Morris Goding  
Access Consulting

Doran Drive Precinct -  
Doran Drive,  
Castle Hill NSW

**Access Review –  
Final v2**

13 July 2021

Dwg No.  
**DA-110-008**

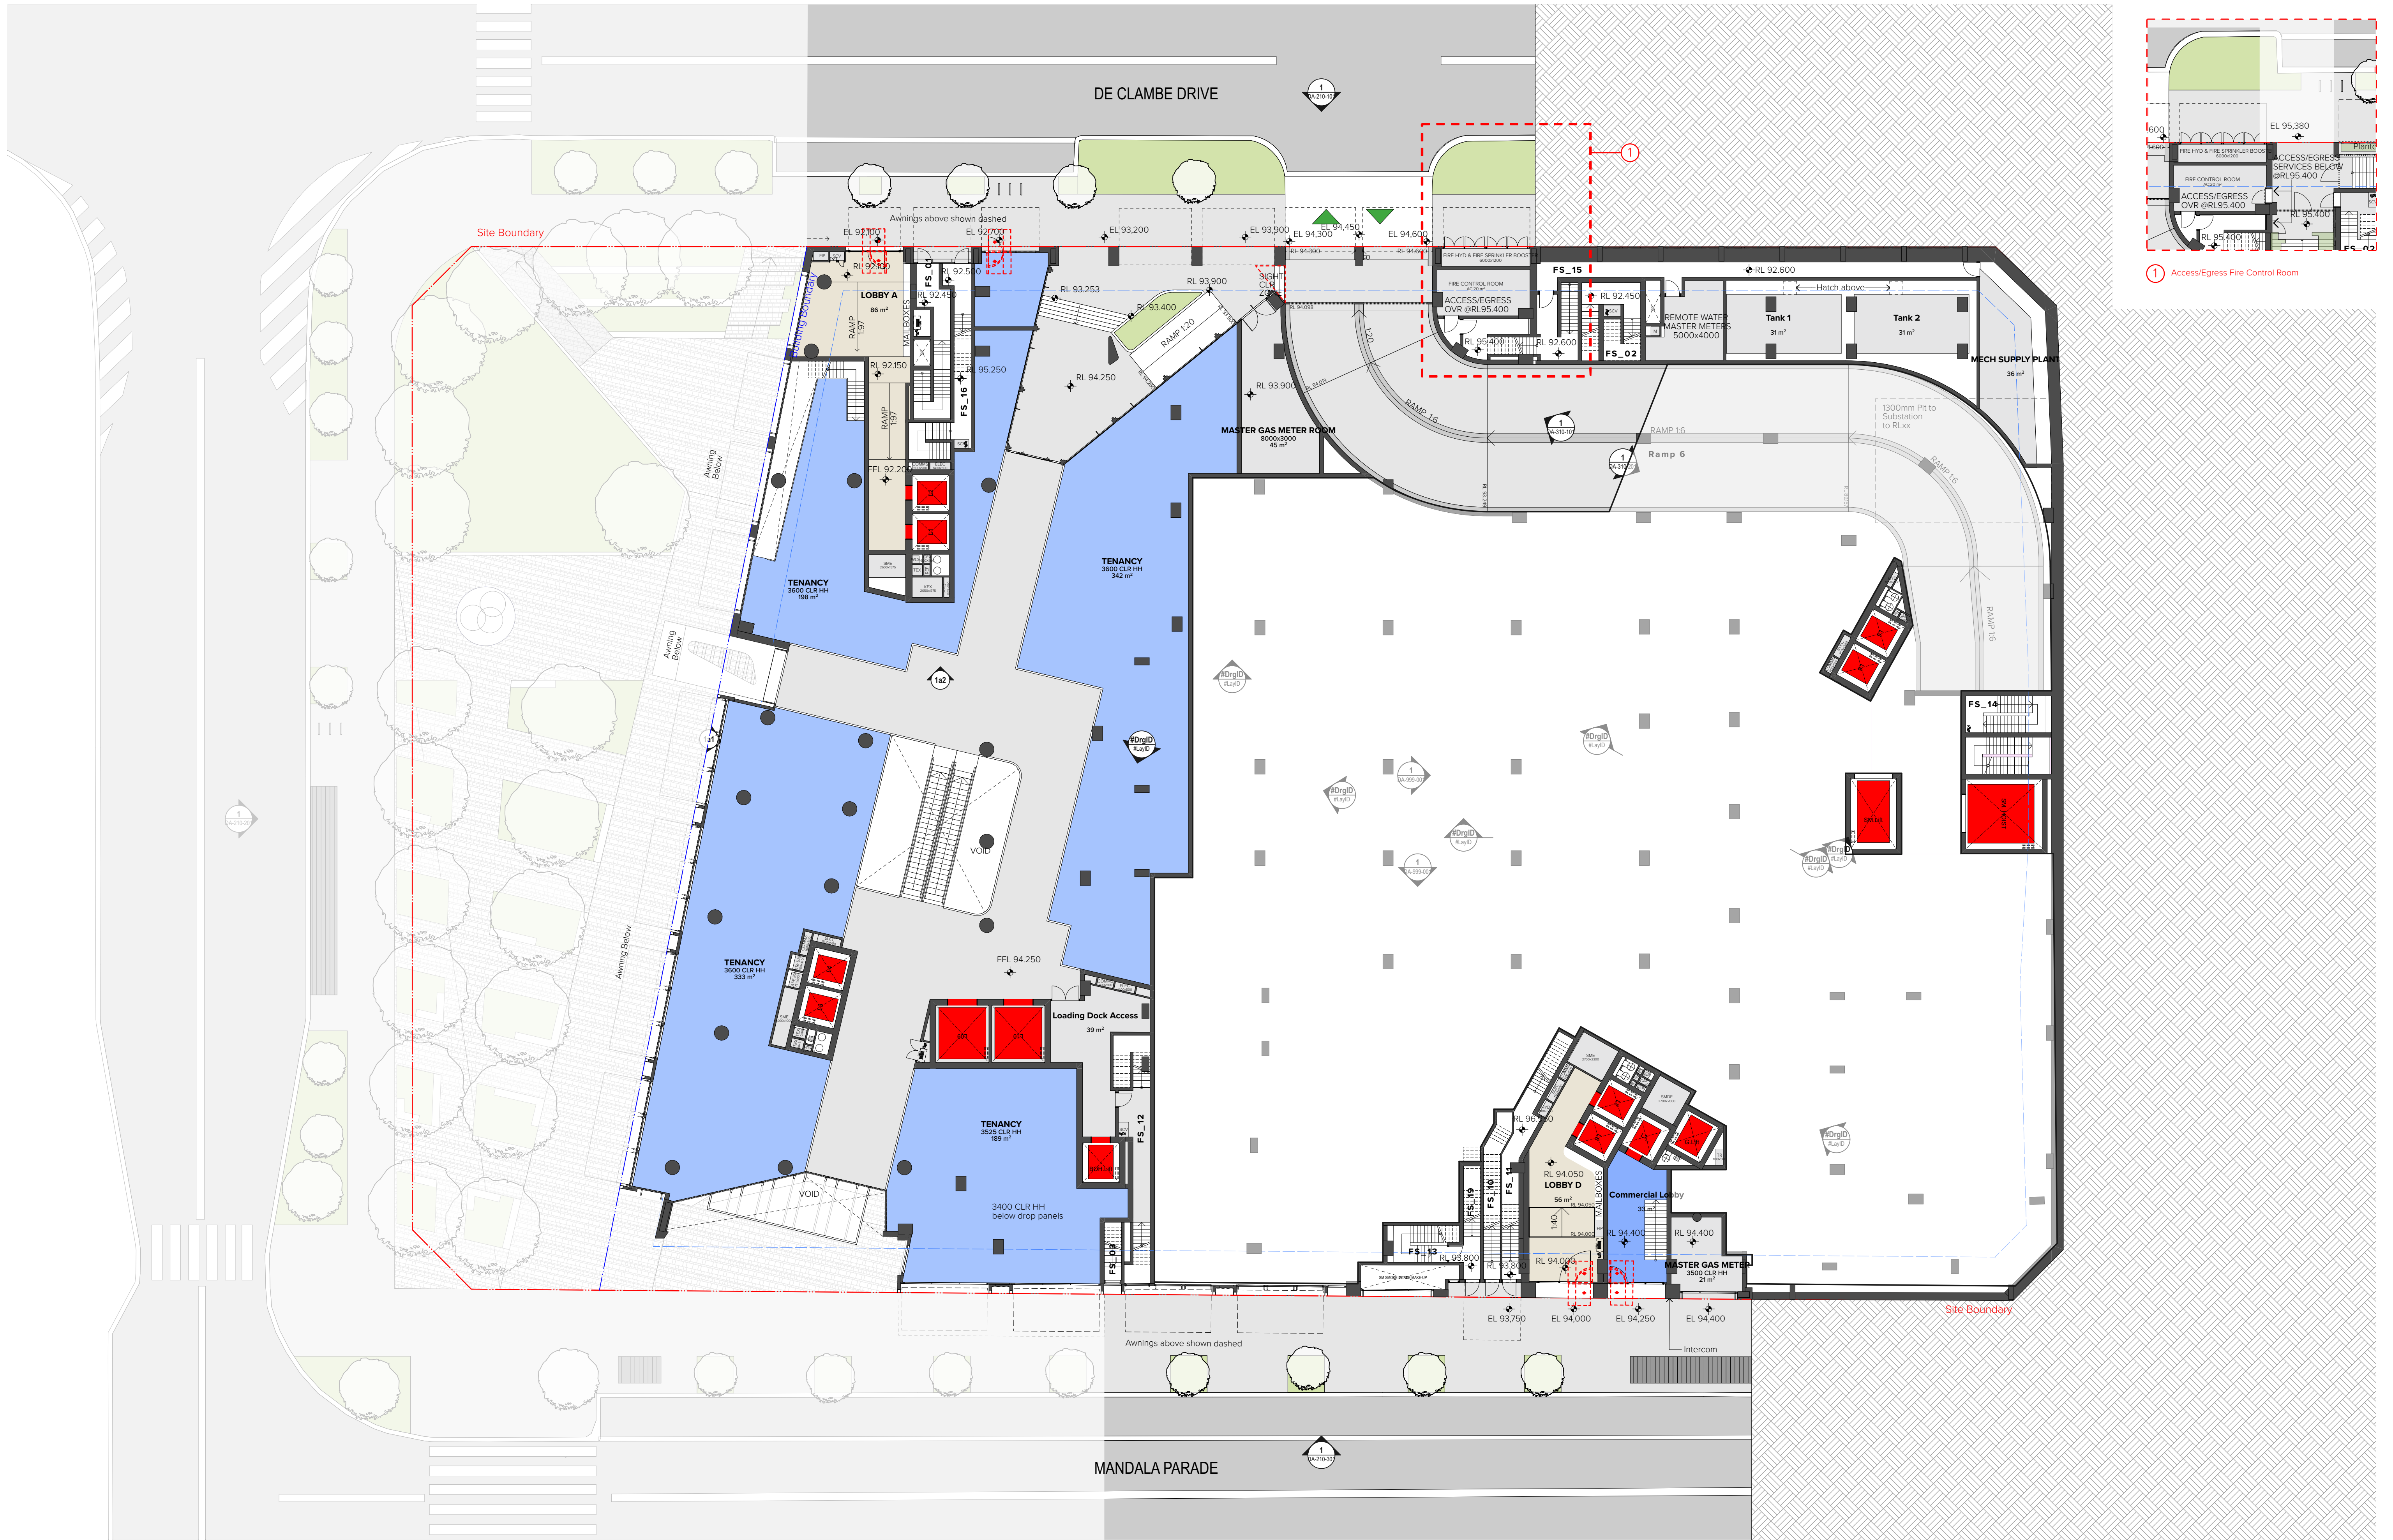
Lobby B (ground floor) - clarification on the location of the continuous accessible path of travel (CAPT) to principal pedestrian entrance (PPE), as it appears that there is a level difference of 75mm to 260mm. Provision of a step ramp is recommended outside and inside to address level differences. Ensure door provides suitable level landing circulations. Ref to AS1428.1 Fig. 25(D).

Lobby B (ground floor) entry door has a lack of latch side clearance and suitable clear circulation. Door is to provide 510mm min. (internal) and 530mm min. (external) latch side clearance, or door is to be automated. There is sufficient space for amendments to be readily made to achieve compliance during a further stage.
